APPLICATION AB/106/15/DOC
NO:

Registered: 04-AUG-15
Site Address: 55/57 High Street Arundel BN18 9AJ

Description of Works: Application for approval of details reserved by condition imposed under AB/41/12 relating to Condition No's 3, 4 and 8 - Schedule of materials, cycle storage & Drainage details

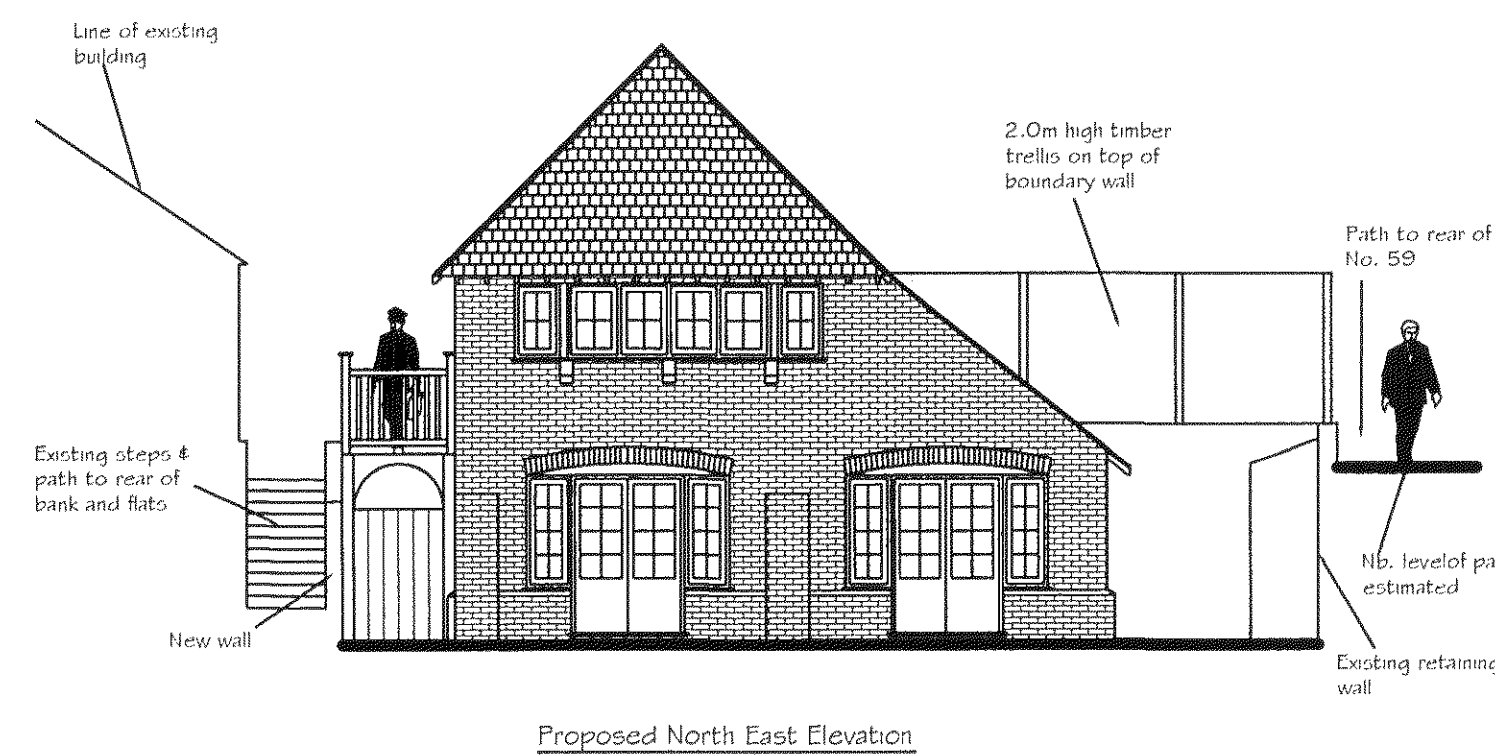
Soakaways have been investigated for surface water drainage, however site constraints mean that surface water would have to be pumped, which is not suitable. The proposed alternative is to take existing surface water drainage runs to the surface water sewer in High Street and utilise those for this development.

A plan will be required and can possibly be provided at short notice from the agent, if it is then possible to discharge the condition through the current application.

Yes that will be fine to discharge the condition
